June 12, 2017

Re: 15 West Street Project: Grand Staircase Enclosure

EXISTING 1st FLOOR PLAN

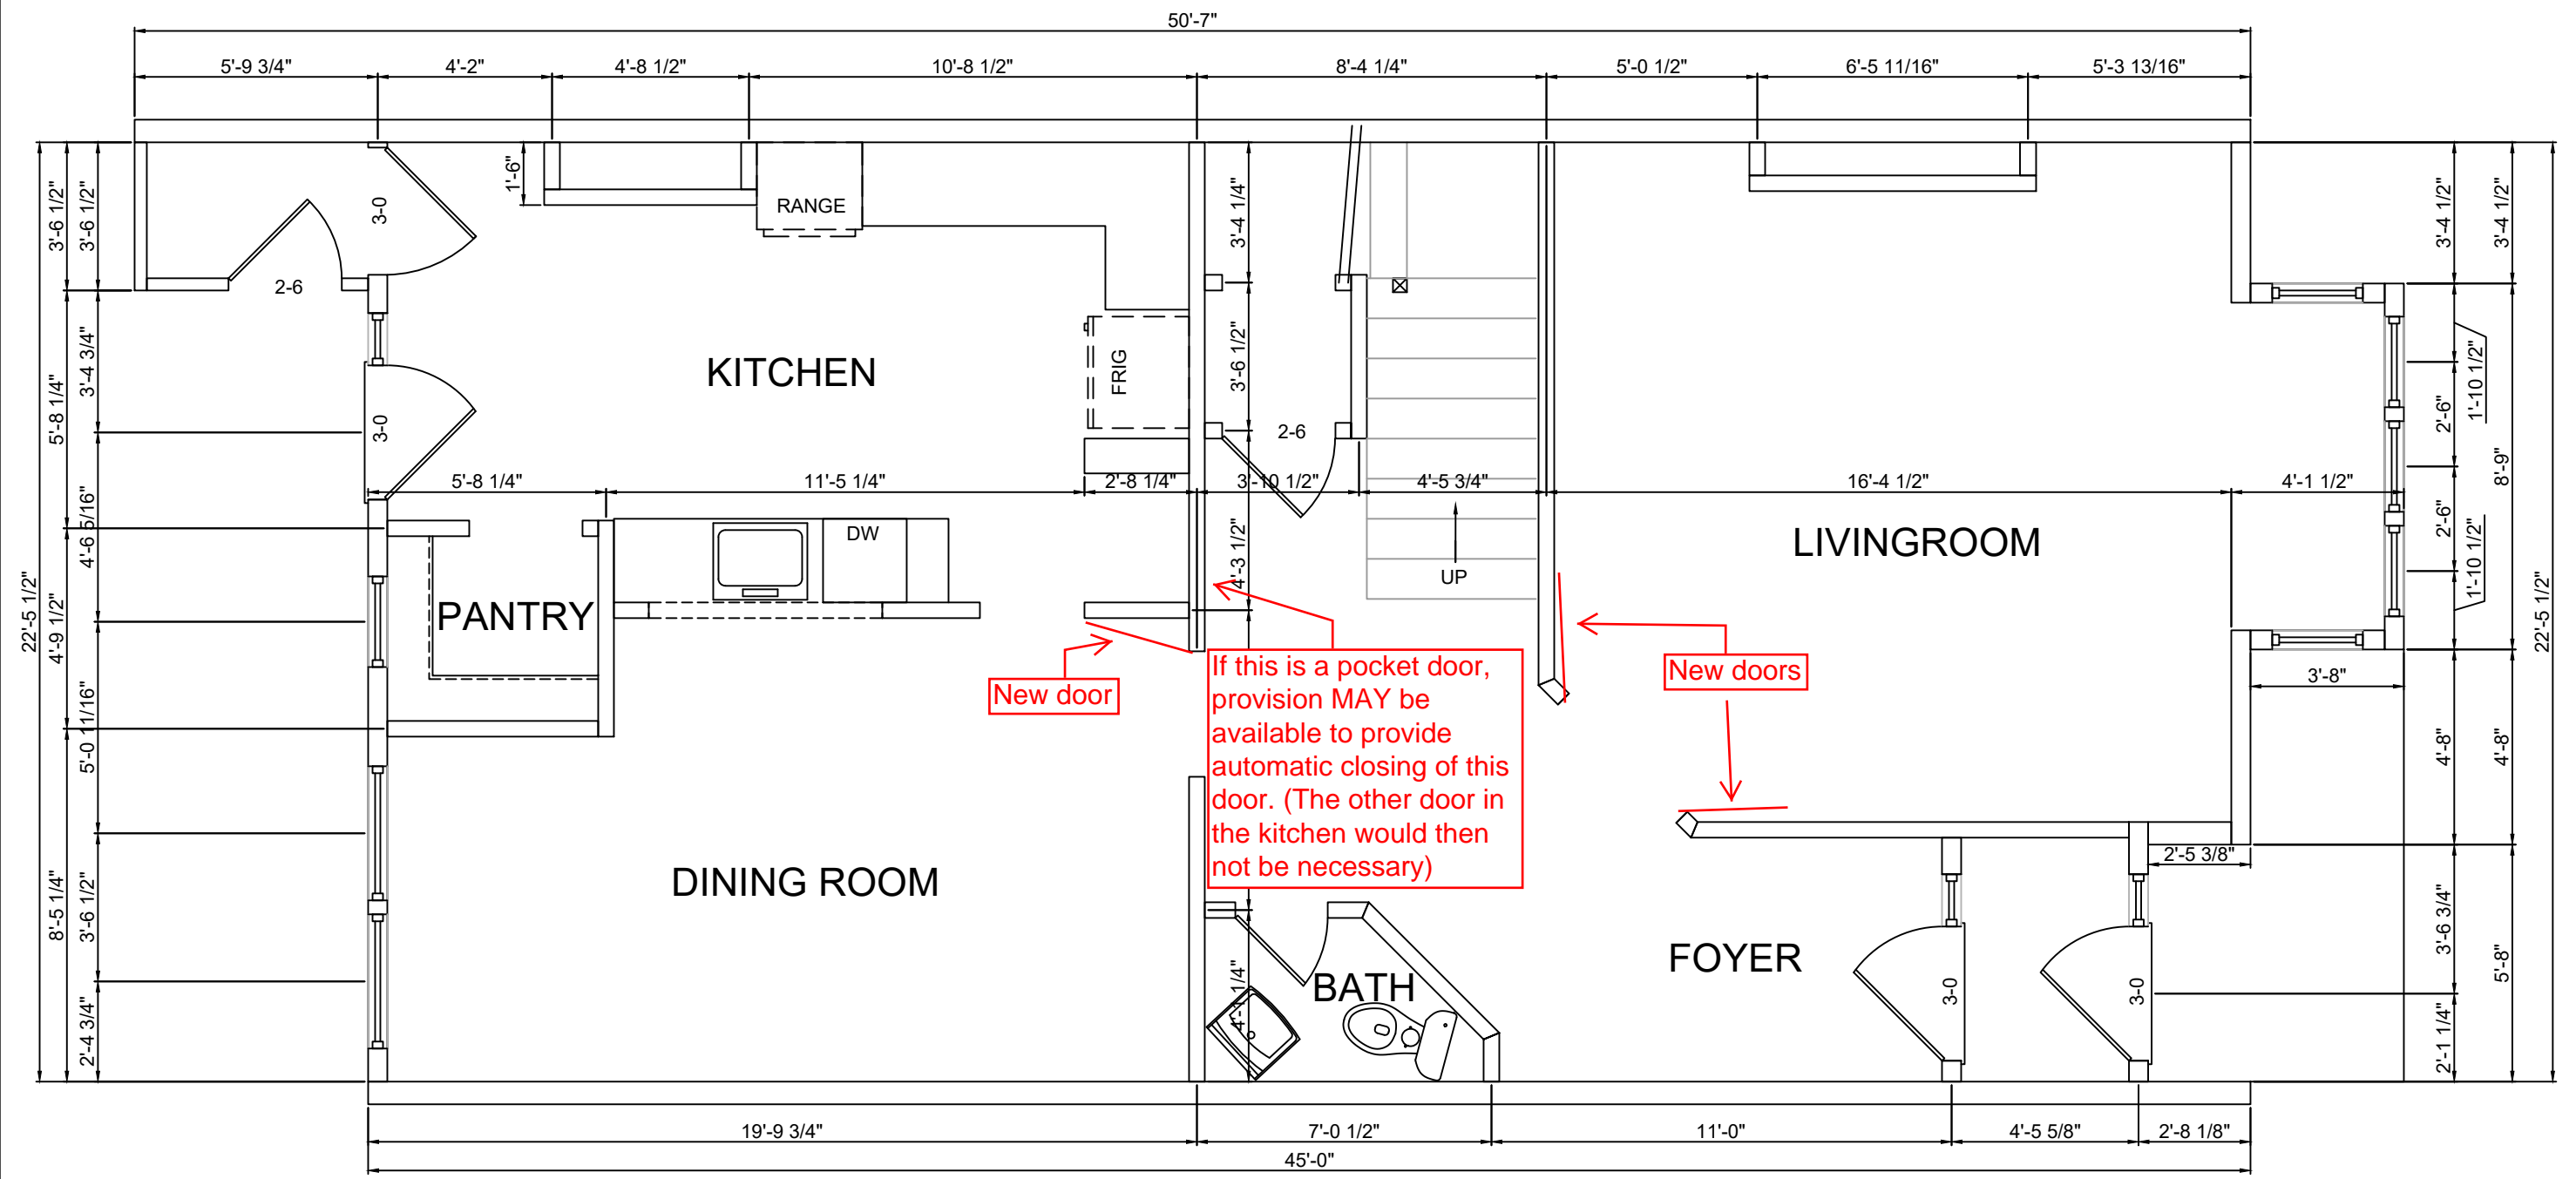
- To provide automatic closers on all bedroom or living room doors entering into the grand staircase.
- To provide additional enclosure to the staircase by adding additional self-closing doors as shown in the attached document.
- That our existing handrail can remain, as long as you deem it graspable according to the intent of the Code.

- ❖ We ask that we be permitted to provide self-closing doors on all sleeping rooms and second floor work areas AND add a single additional self-closing door to provide protection from the kitchen/dining area (highest hazard area) as depicted by our FPE, and
- ❖ We ask that we be permitted to leave the passageway into the living room open (not provide the doors shown by our FPE), keep the current architectural handrail, and not provide the additional door on the second floor (since all other room doors are self-closing).
